21 Sep 2018

**Planning Application, R/90/18/HH, for No. 9 Park Drive, Rustington
Amended Plans, (dated 5 Sep 2018), for same**

203 Proposed East Elevation

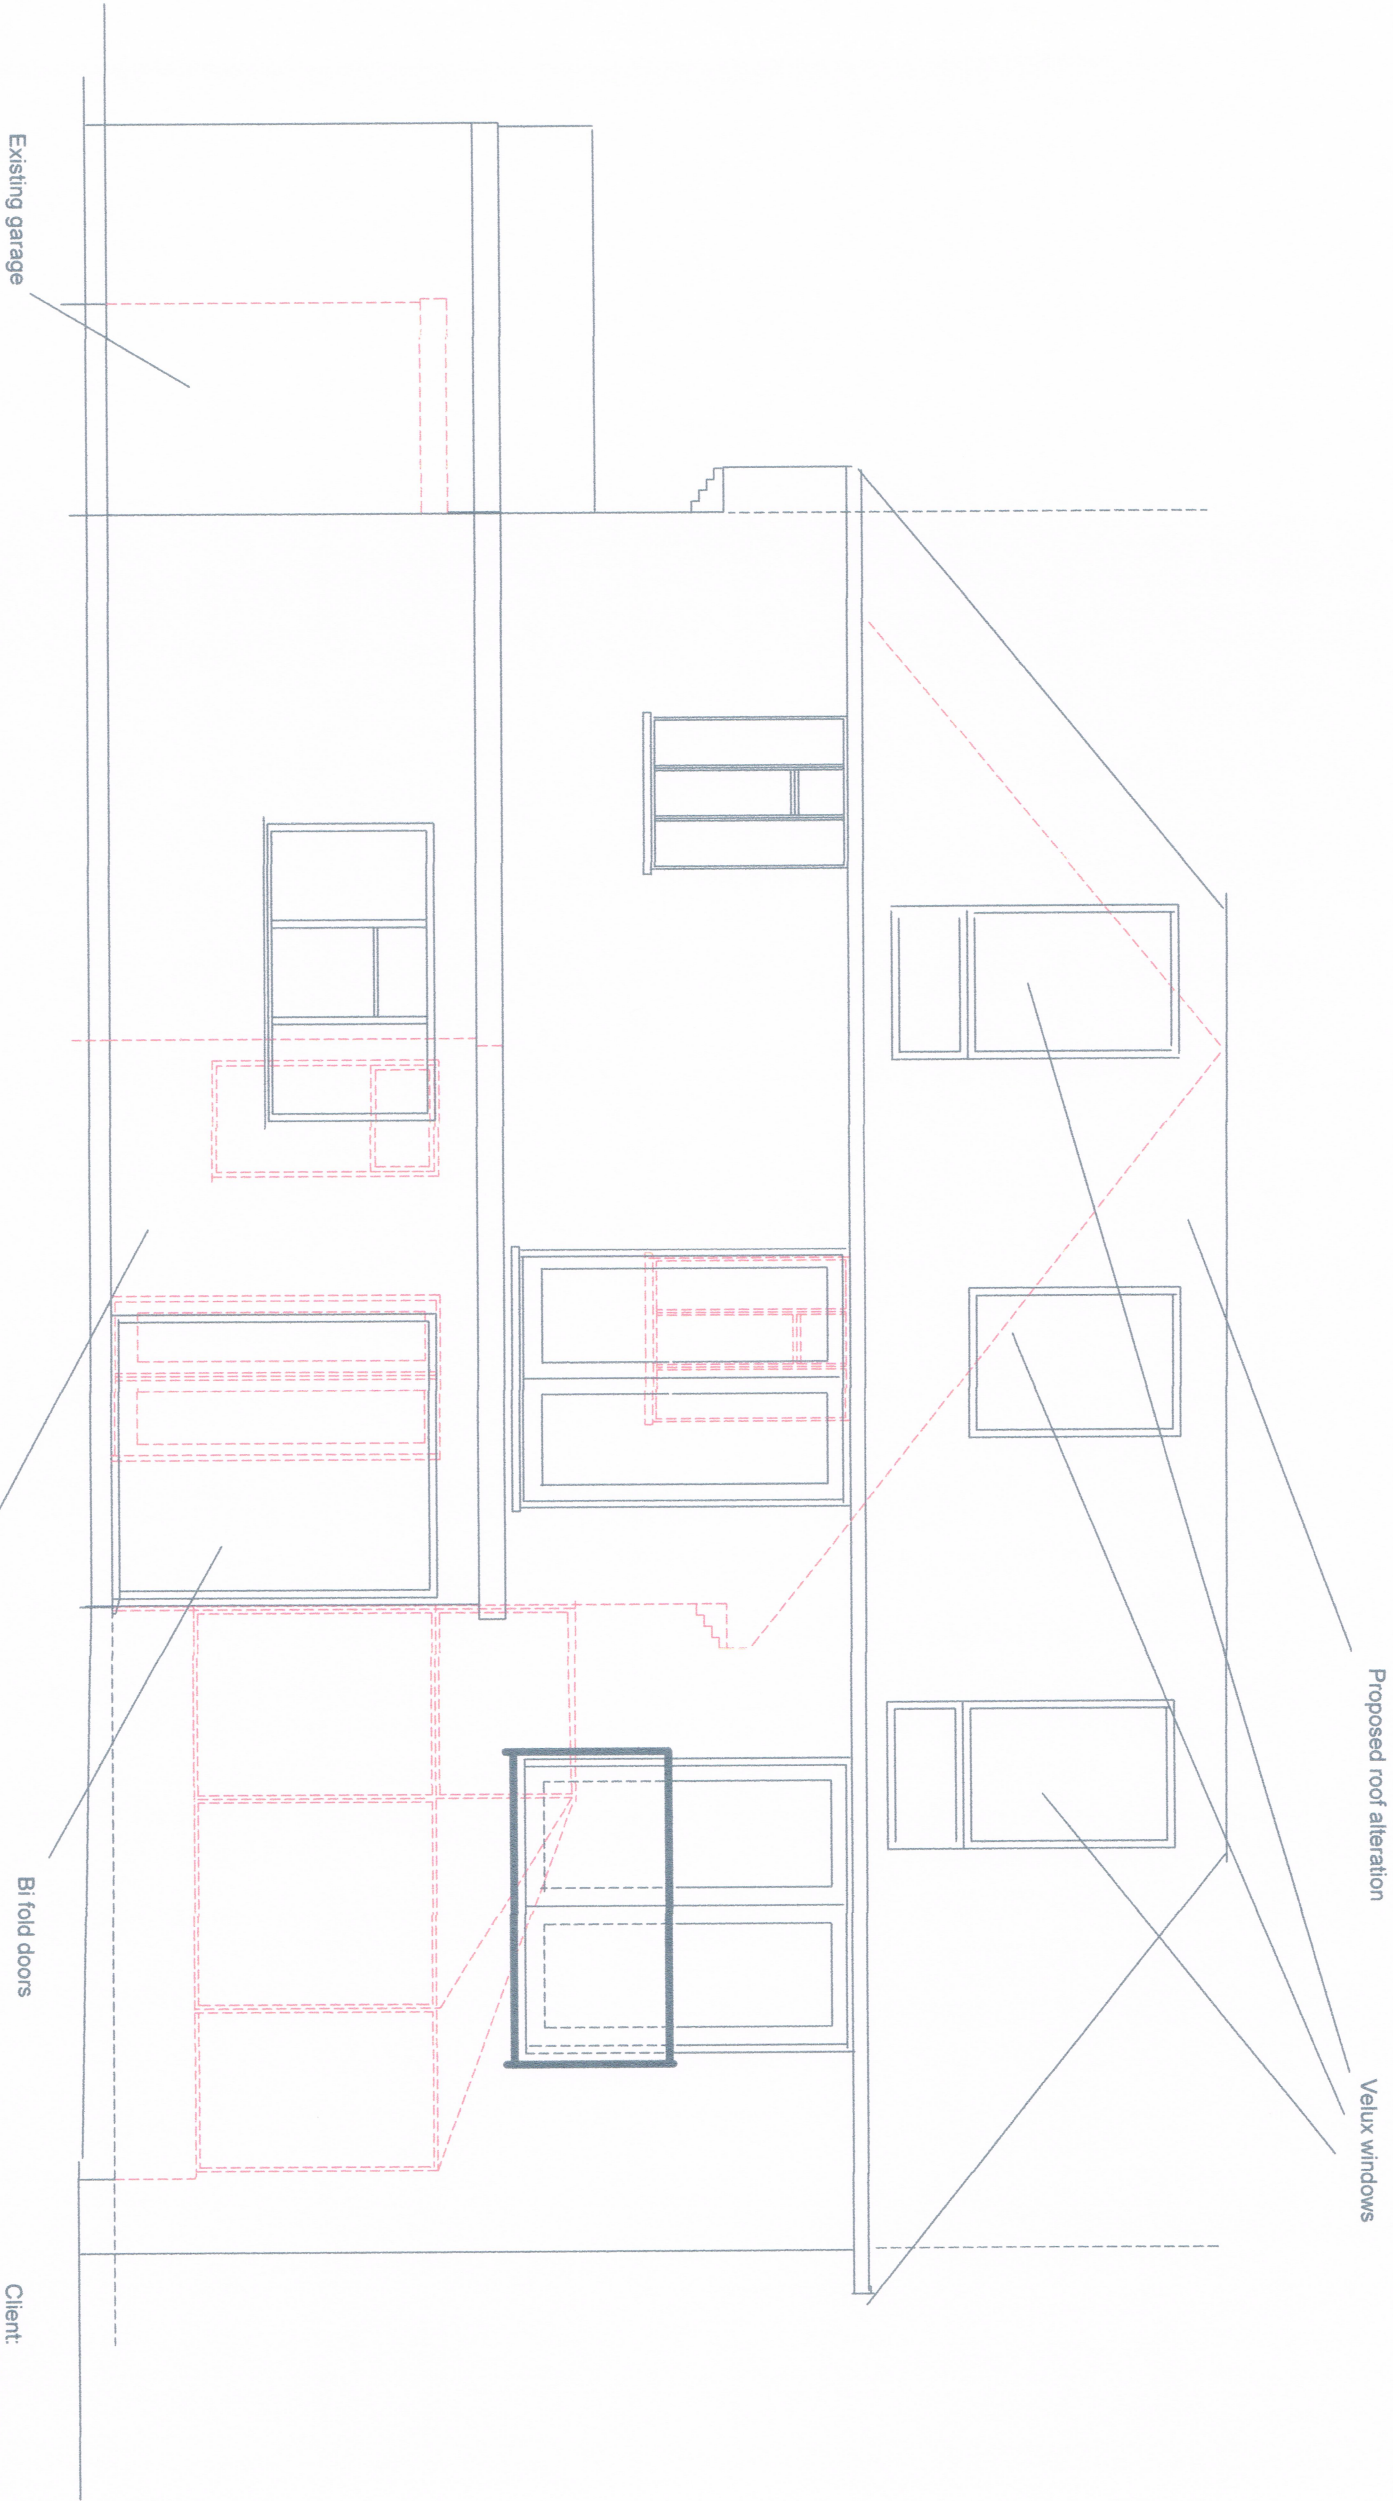
The amended drawing for the east elevation shows a reduction in overall height of approximately half a metre. Also, by virtue of realigning the roof contour to match the existing cable ends, it has resulted in a reduction in the frontal area of the east elevation of the property. However, in numerical terms this area is some 35% greater than that of the existing property, and this large facade therefore still constitutes an unacceptable overbearing presence

In the Pre-Application Advice, (ref PAA/38/18 dated 11 April 2018), Mr Andrew Wood made it abundantly clear that any extension must sympathetically relate to, and visually integrate with, the existing property and must not have an overbearing effect. He also emphasised that the extension must be visually subservient to the main building. Quite clearly the amended plans satisfy none of the above criteria

As was stated in the original letter of 28 July 2018, it is difficult to envisage how any three storey extension of this magnitude could ever be considered visually subservient, since it changes the whole character of the original property
